PROPOSED 44MW PADBURY SOLAR PARK - Planning Application Ref: 22/03873/F

As a professional Agronomist with over ten years' experience in the agricultural industry, I am writing with regards to the Agricultural Classification of the land at the proposed Padbury Brook Solar Farm site.

# Appendix 6 - Map of ALC Grade

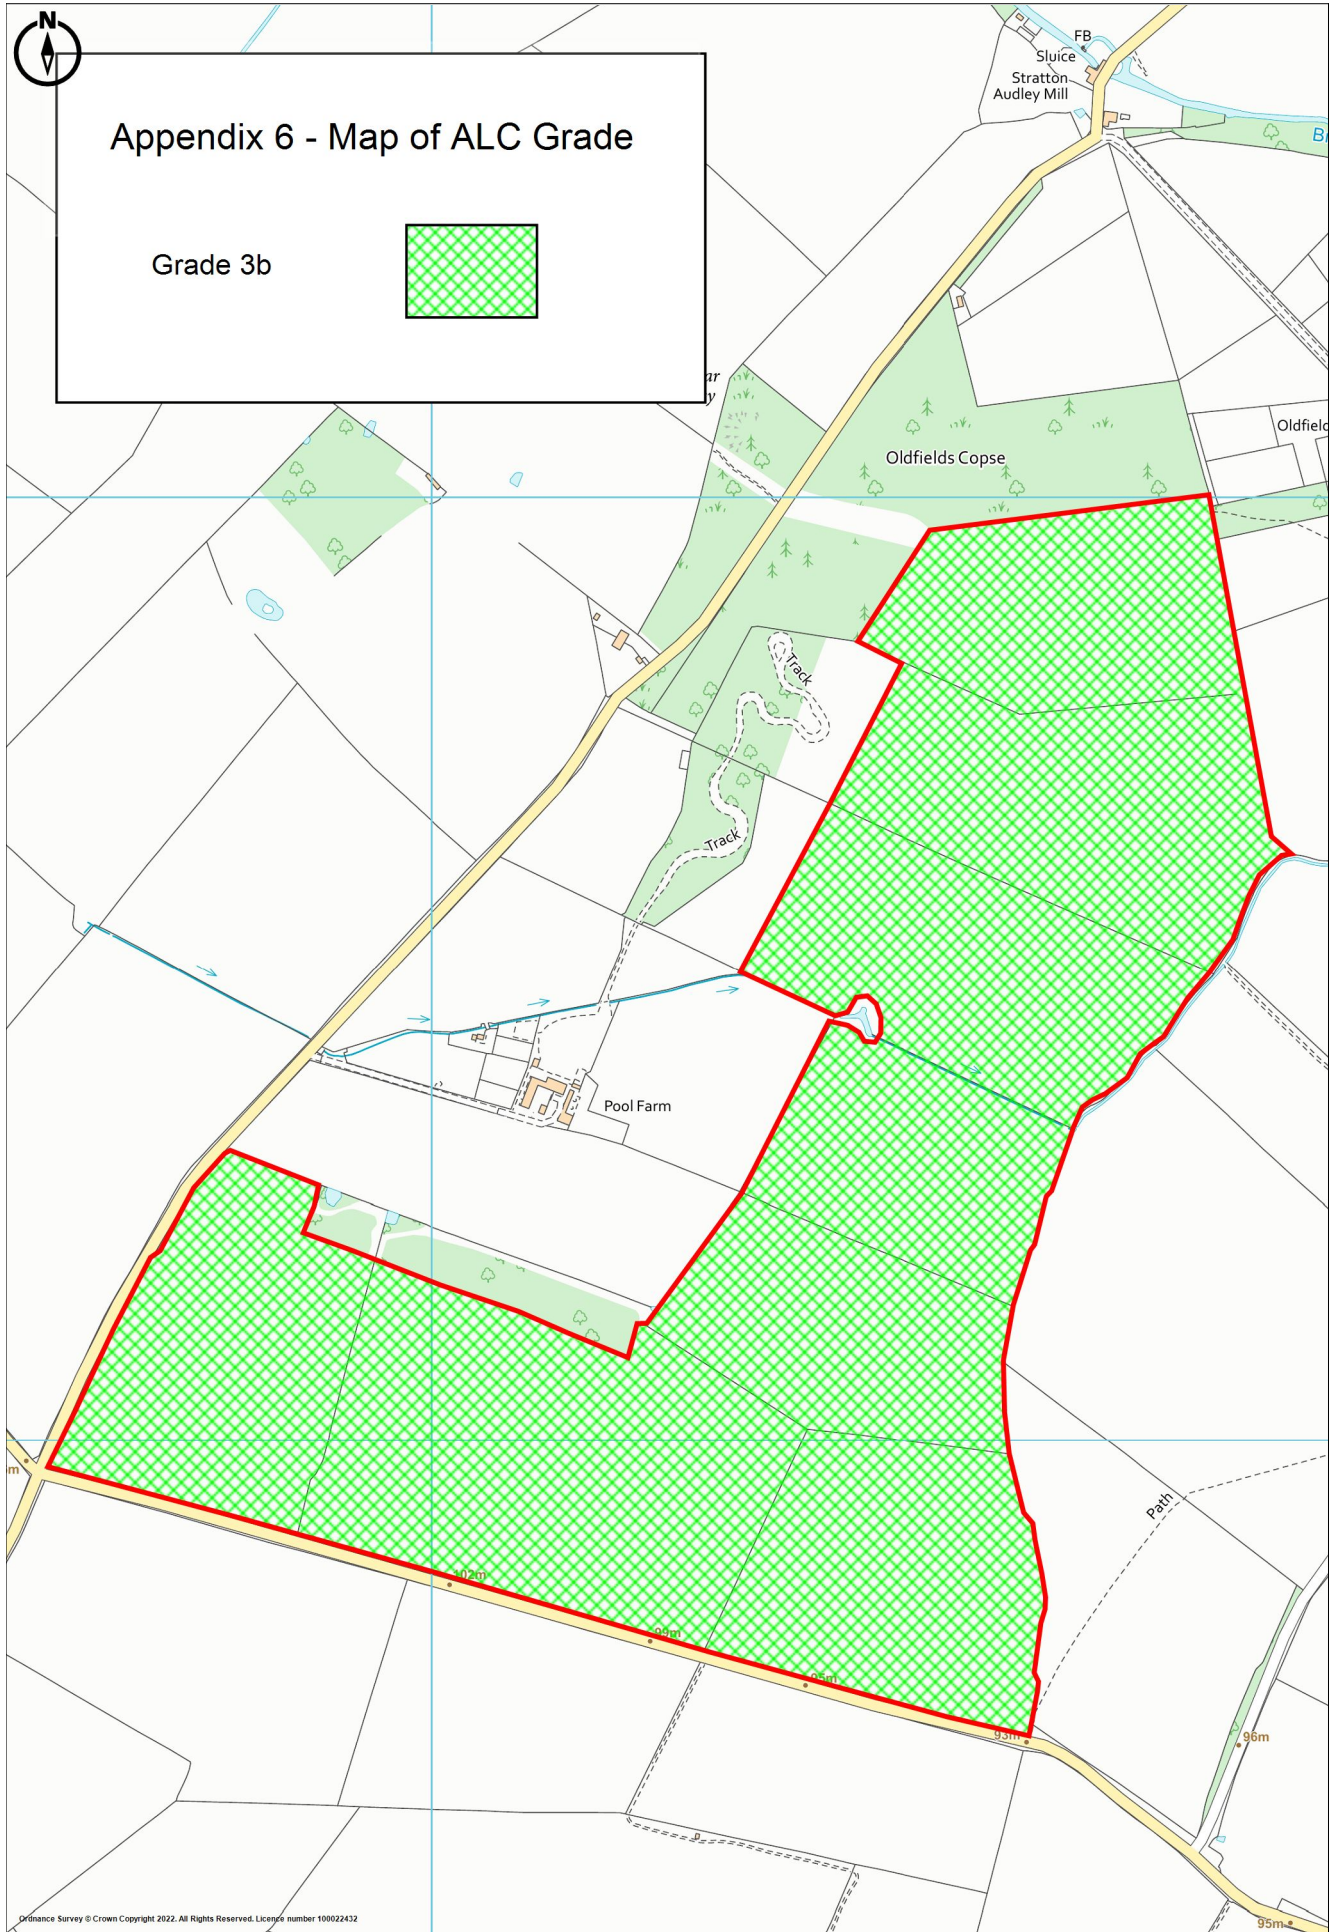
The report grades the whole parcel of land as 3b. This does not consider the undoubted variation within the fields. Over the years the previous farmer of 20 years, has grown a wide range of crops, which include winter wheat, winter beans, winter OSR (root based), winter and spring barley. This is a clear characteristic of 3a land.

In addition, the previous farmers never grew grassland and so the land in question is clearly not in line with the industry recognised characteristics of 3b graded land.

The entire grading system and differences between 3a and 3b is grey. It requires an element of interpretation, but based on the facts I believe the land in question fits well within the 3a category. The greatest weight should be applied to historic data and therefore the land clearly fits into the 3a classification category for human food production.
